## City of Ryde Submission 96 Anzac Avenue West Ryde- SSD-81610714

**Council File reference: COR2025/228**  
**Submission Date: 26 February 2026**

## EXECUTIVE SUMMARY

CITY OF RYDE LEP 2014_PROPOSED FLOOR SPACE RATIO MAP

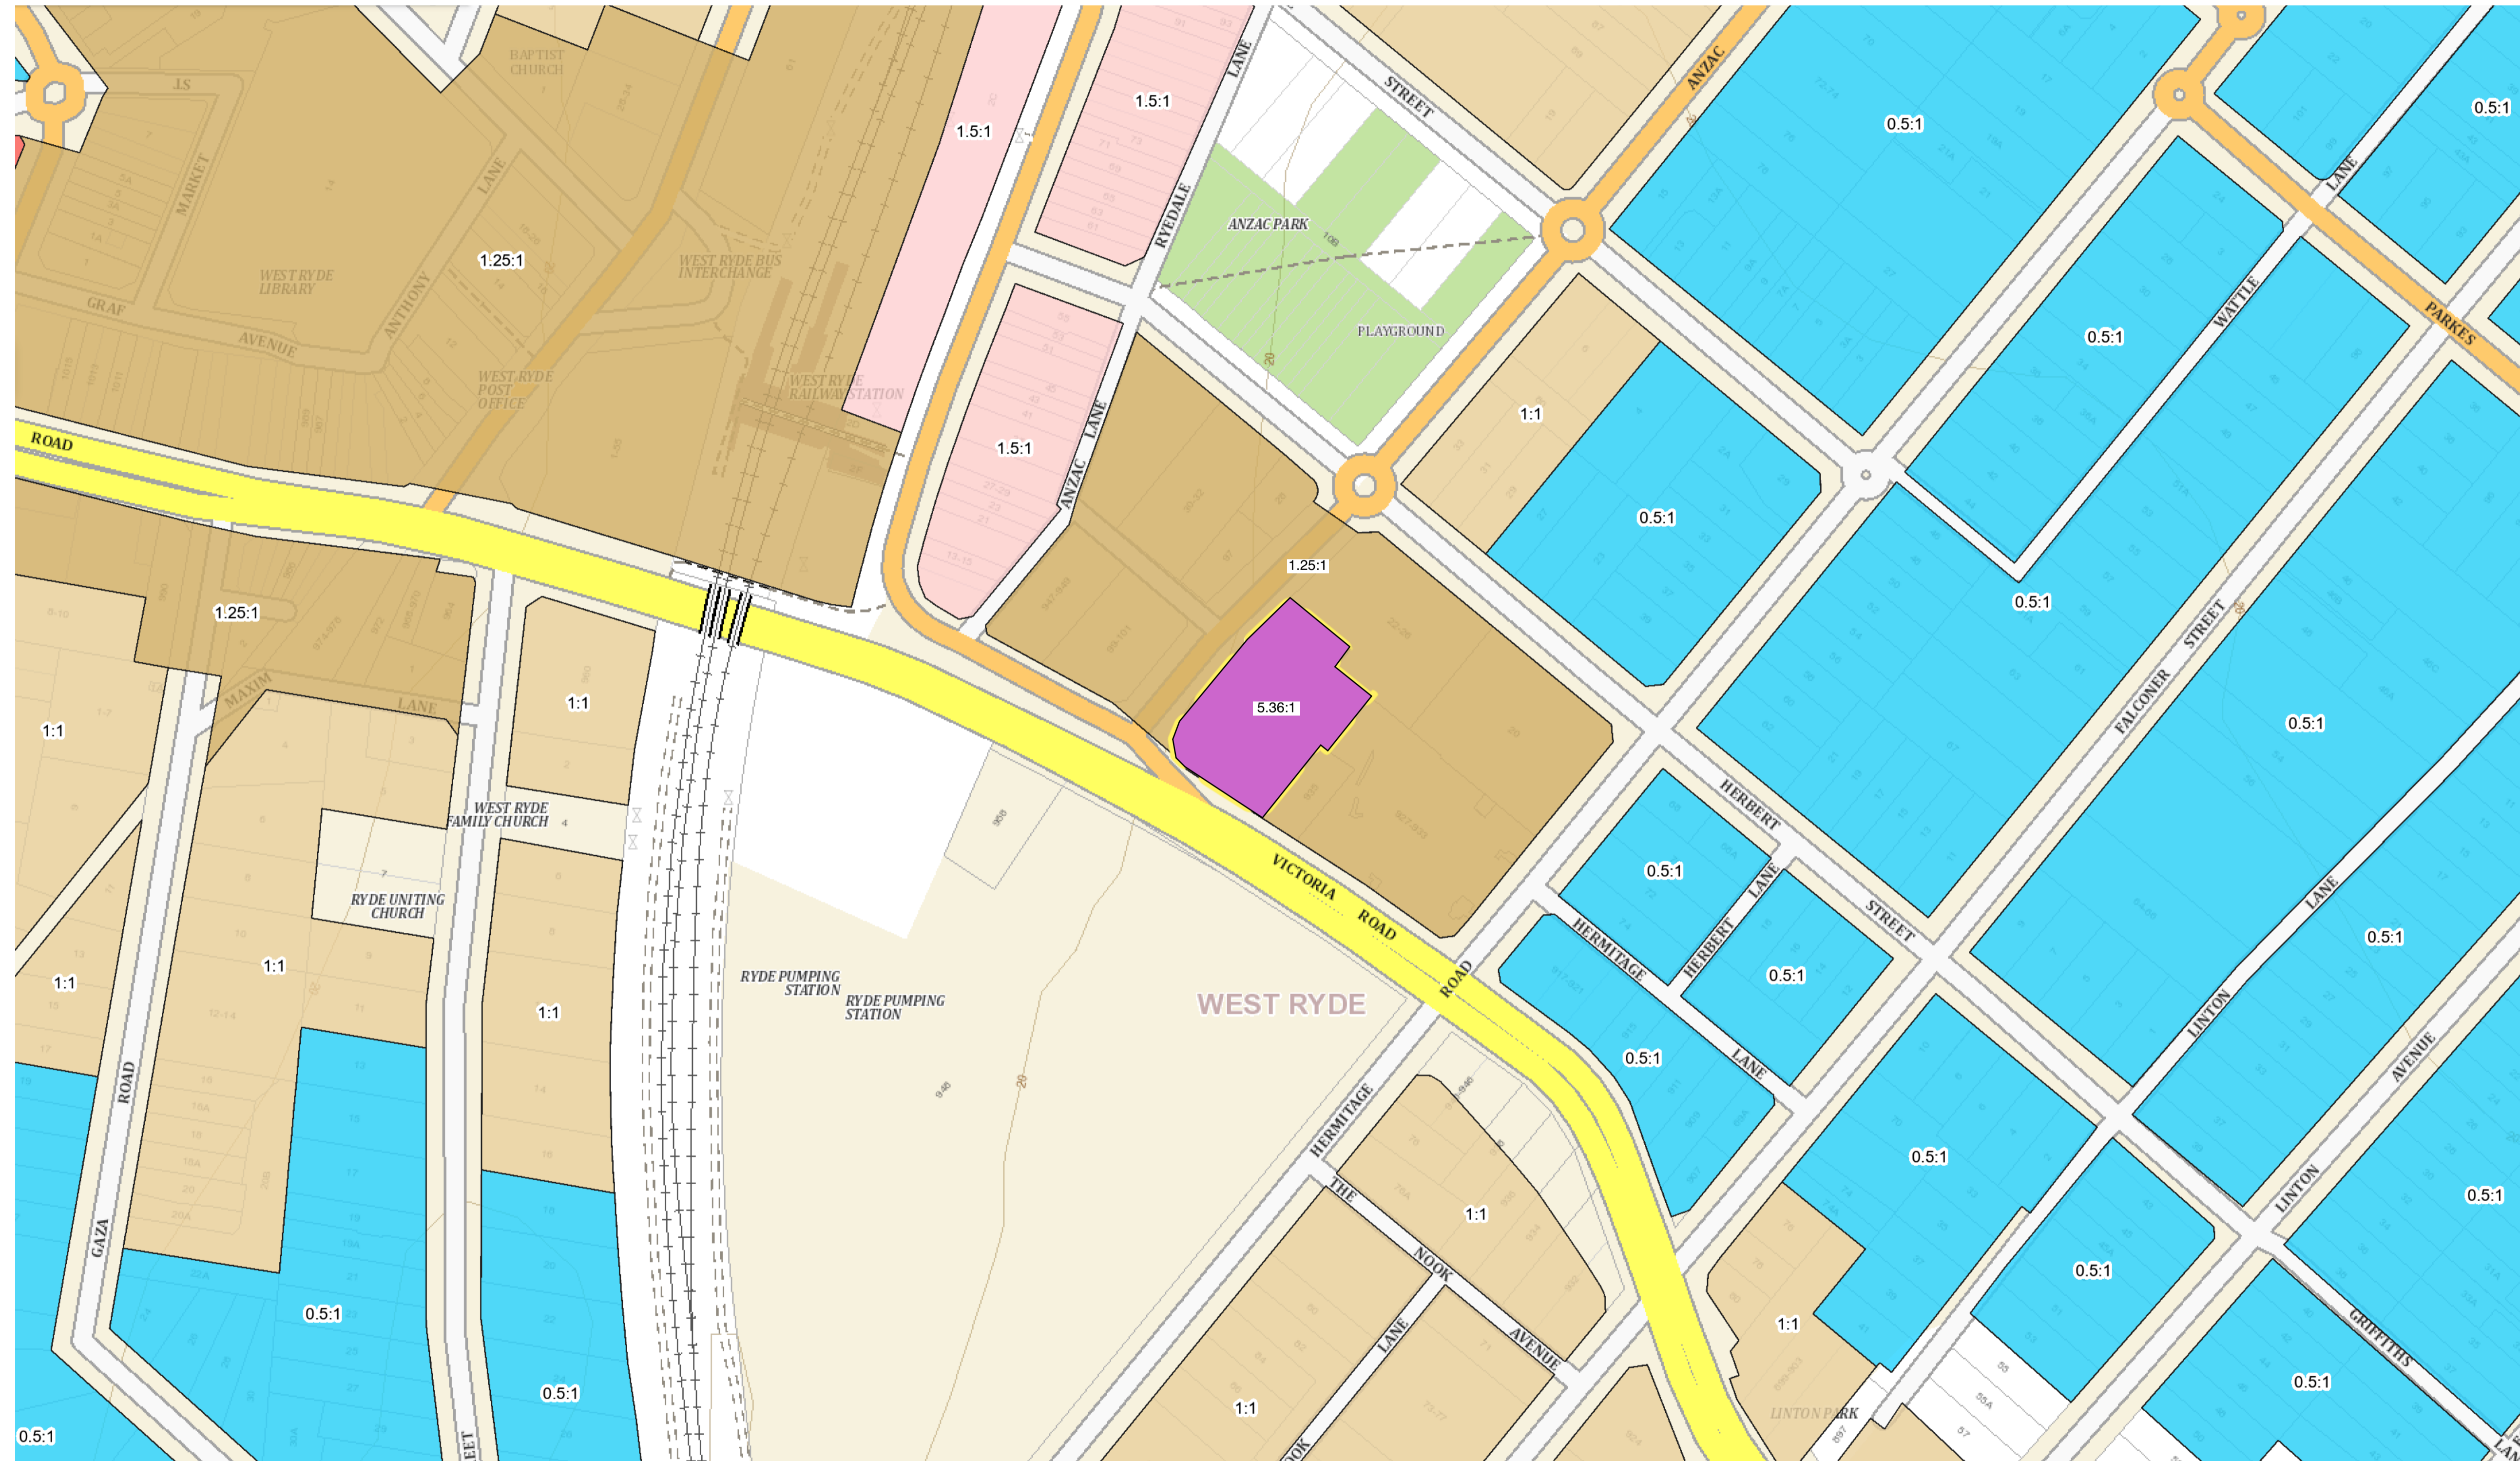
- Increase the maximum permitted building height from 15.5m to 80.5m.
- Increase the maximum permitted floor space ratio from 1.25:1 to 5.36:1
- Maintain the existing MU1 Mixed Use zoning.

The proposed amendments to Ryde LEP include increasing the maximum Height of Building from 15.5m to 80.5m and increasing the maximum Floor Space Ratio from 1.25:1 to 5.36:1. If approved, the development will result in the tallest building with the highest FSR in West Ryde and Meadowbank area. It is out of scale with the surrounding predominately 4-5 storey mixed use/residential development. The proposed density controls are also significantly higher than other recent development proposals in the area:

Given that the strategic justification is insufficient, the proposed HoB and FSR controls are not supported. The proposed development is likely to result in an isolated tower development with inappropriate building bulk and is inconsistent with and unsympathetic to the predominant local character.

CITY OF RYDE LEP 2014_PROPOSED BUILDING HEIGHT MAP

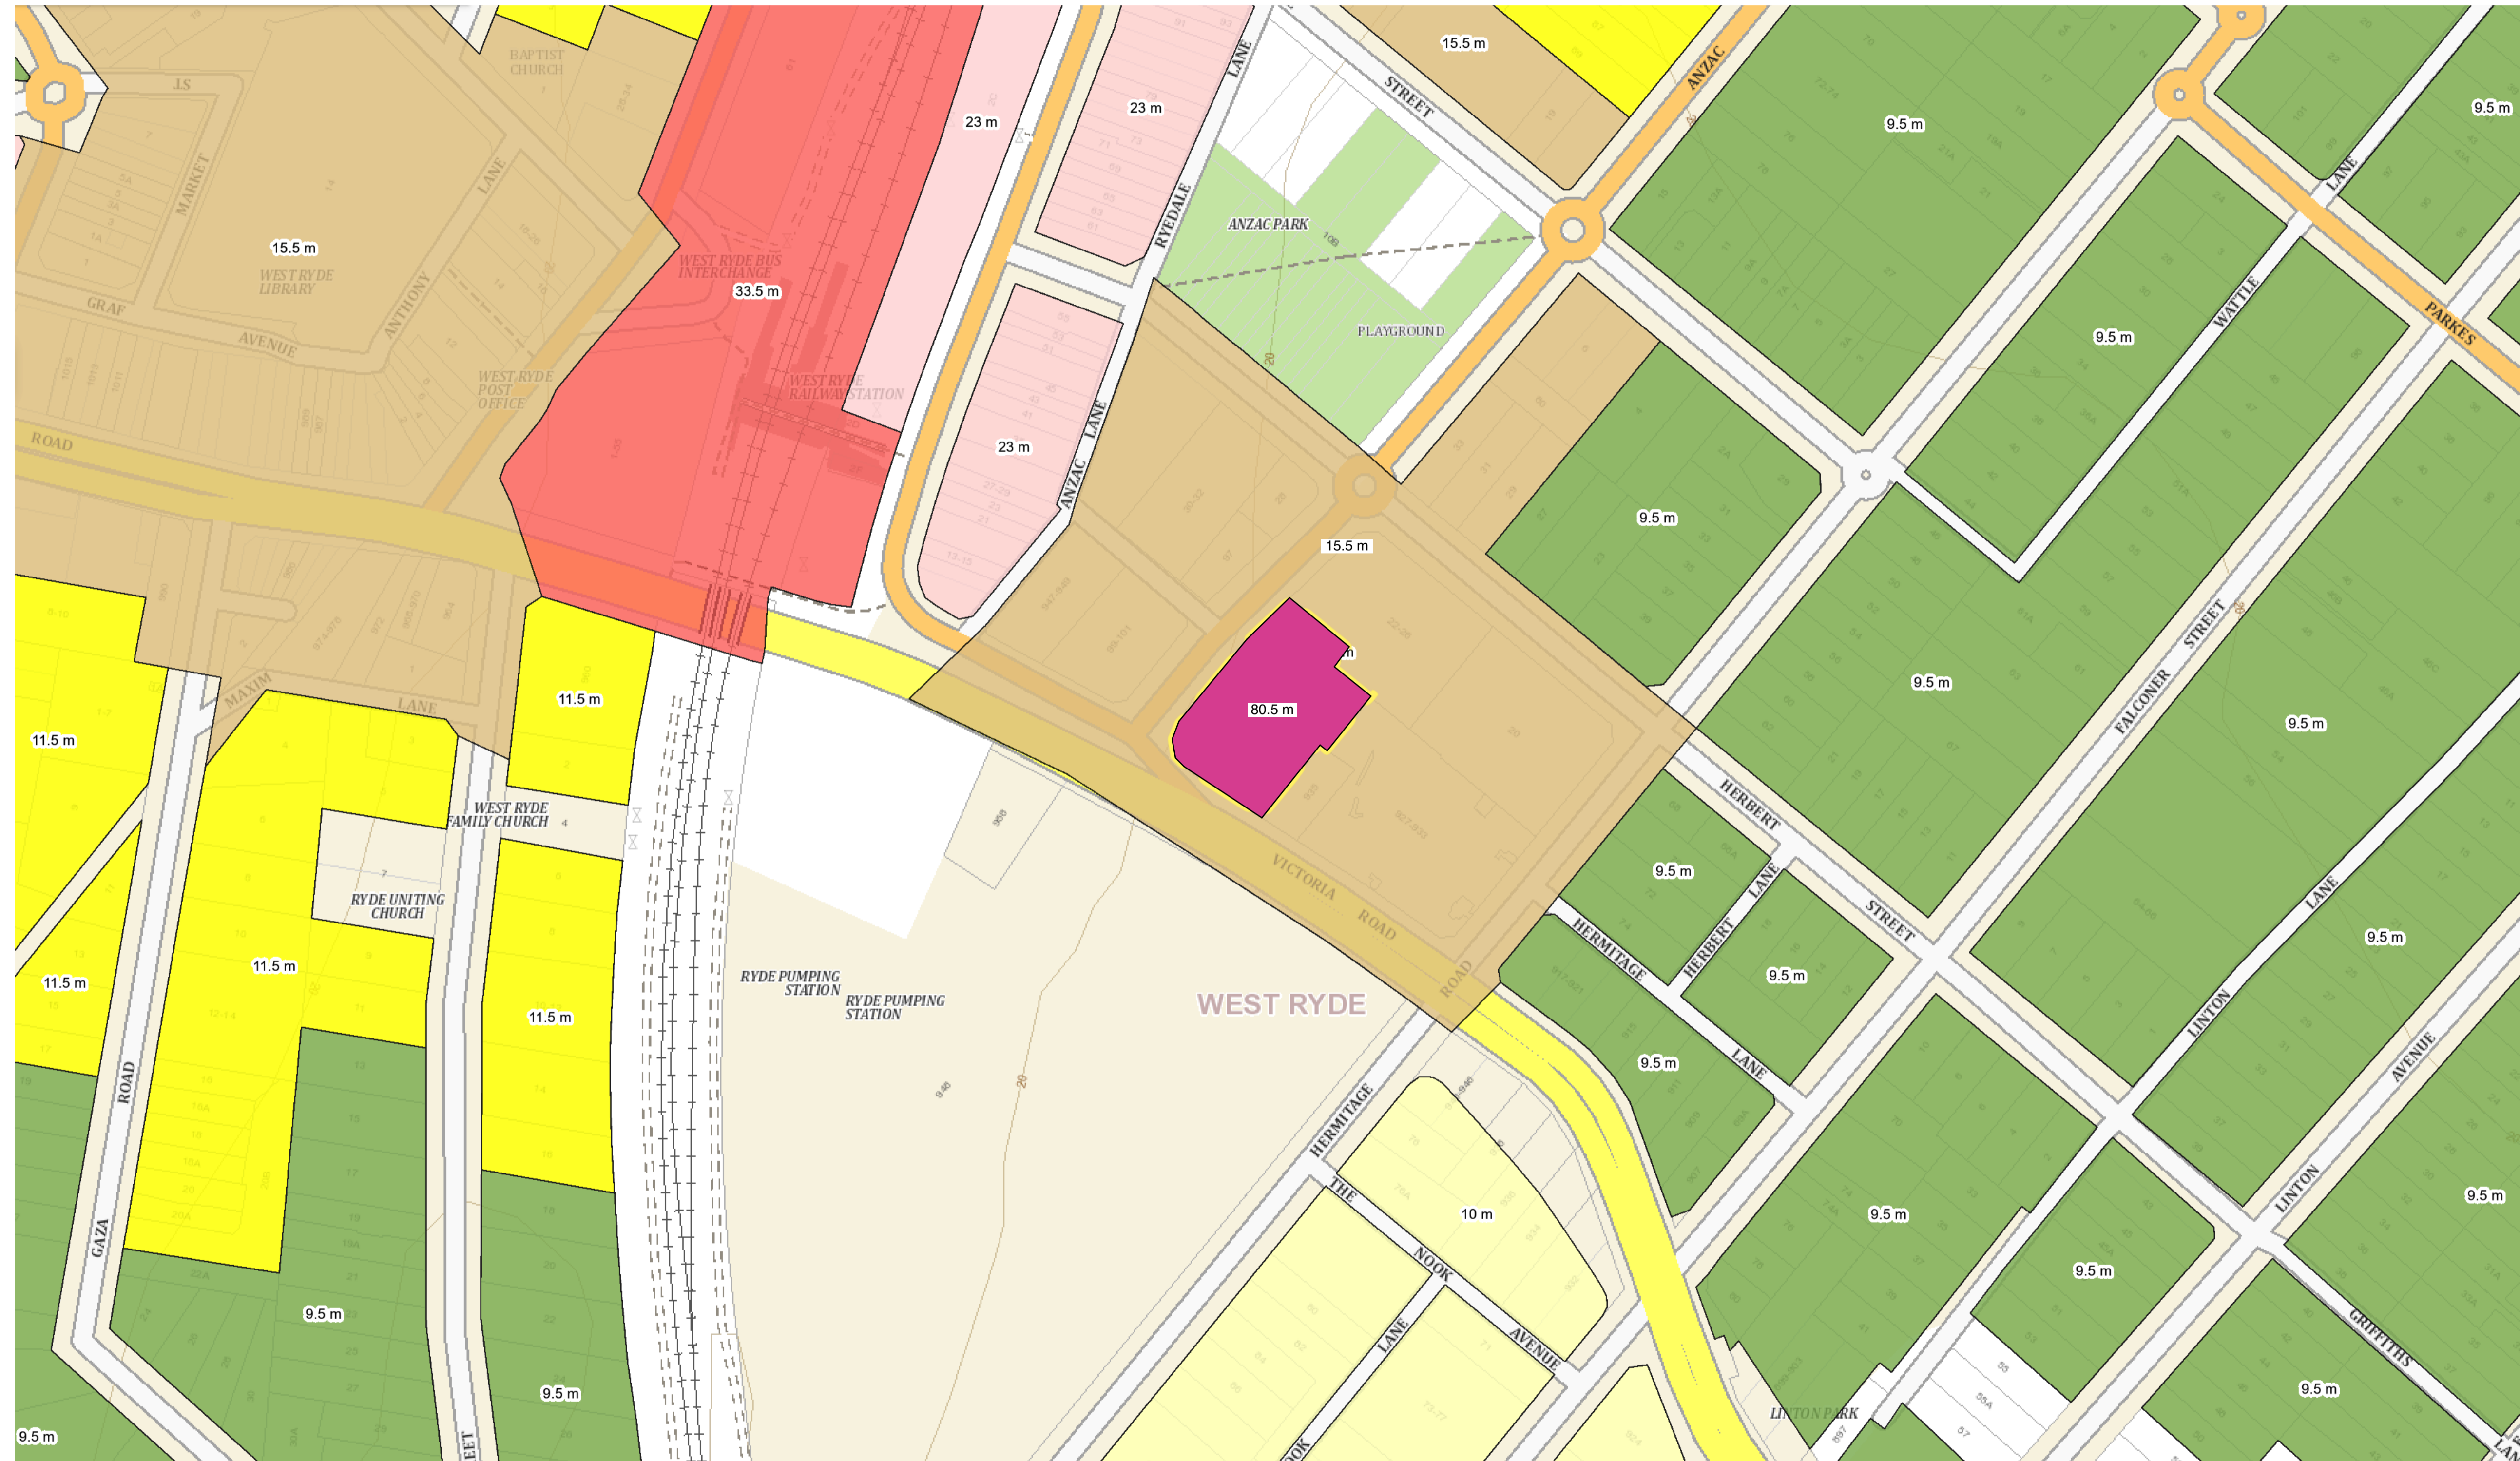
It is recommended that applicant consider reducing the HoB and FSR to align with the predominant existing and future local character of West Ryde.

**GROUND FLOOR PLAN**  
SCALE 1:350

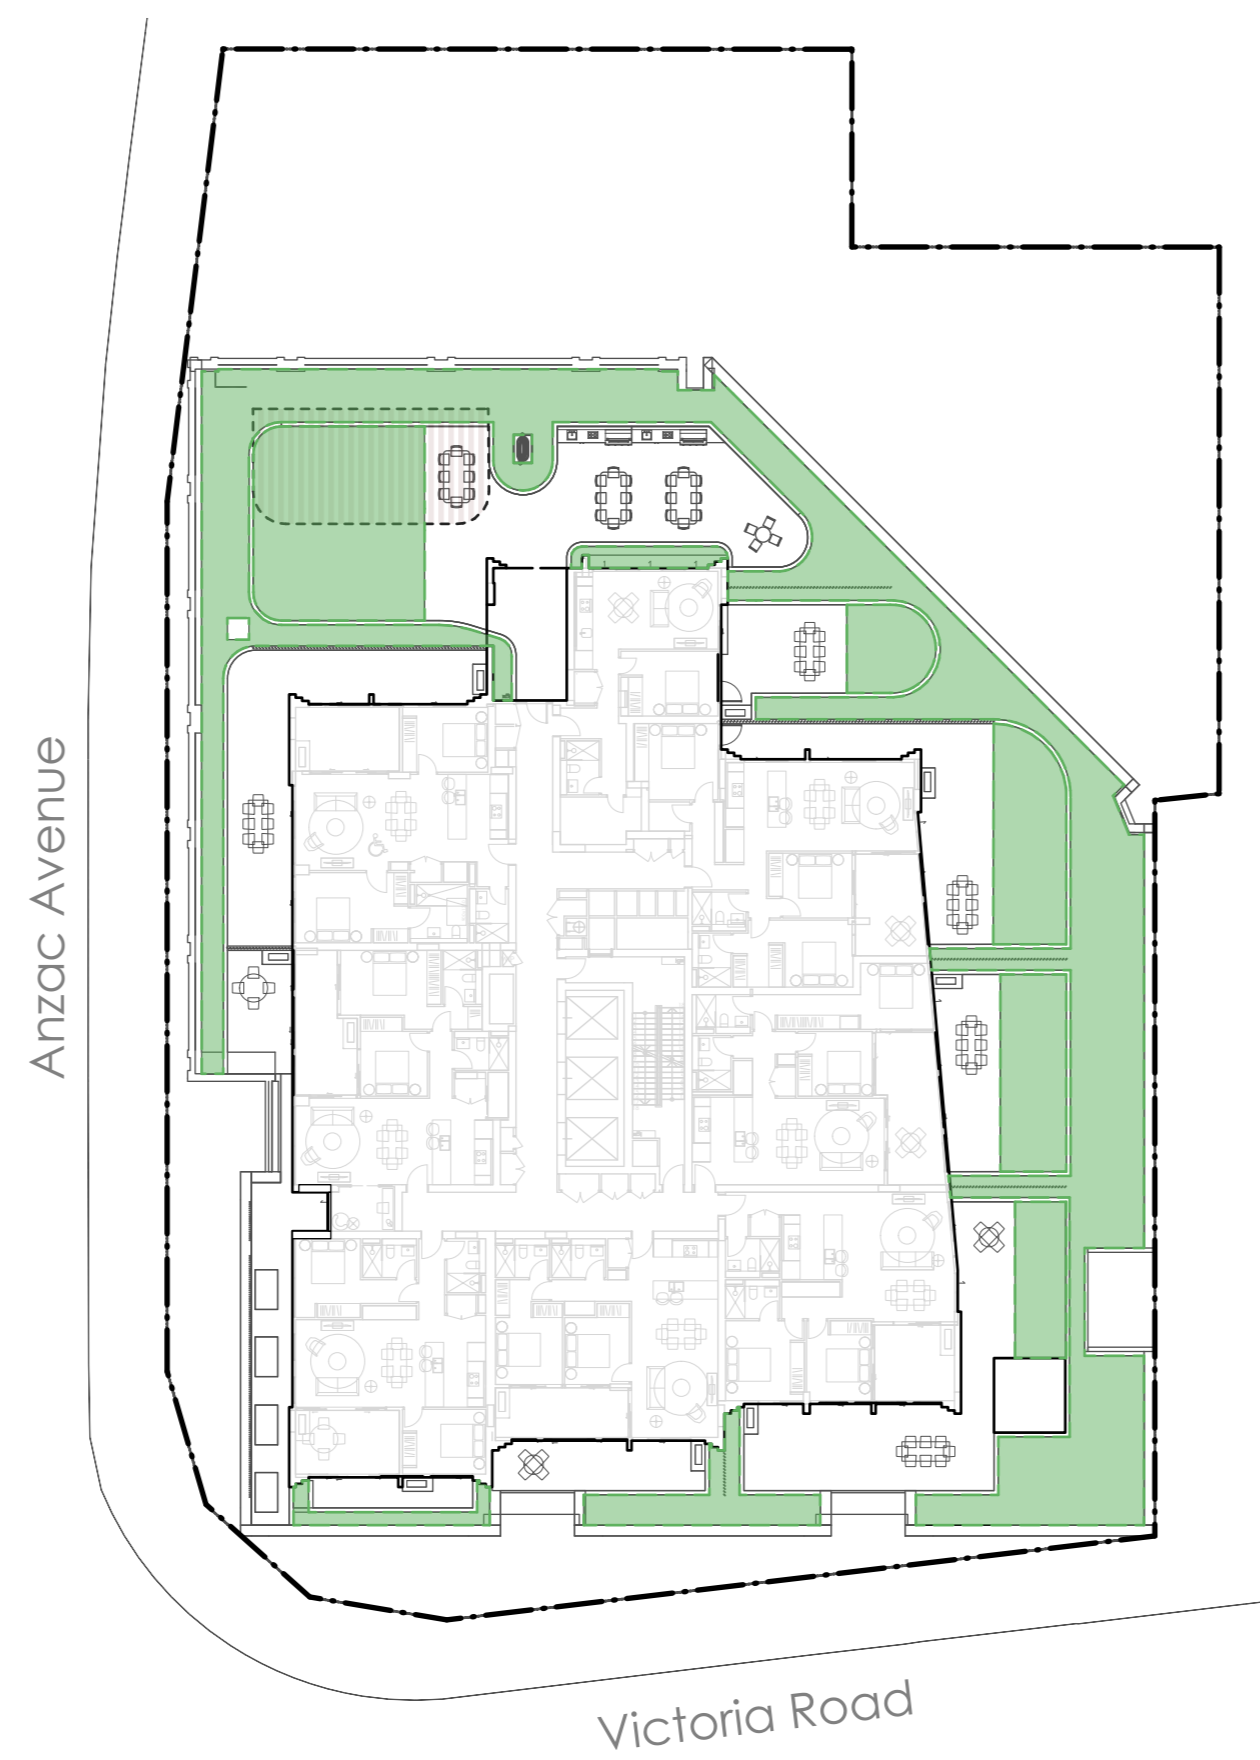
- d. **Deep soil zone:** The deep soil zone must have a minimum dimension of 6m, and therefore the corner area with a width of less than 6m, highlighted in the snip below, should be excluded from the calculation.

- vi. Revisit the deep soil zone calculation to ensure the required 7% of the site area is achieved.
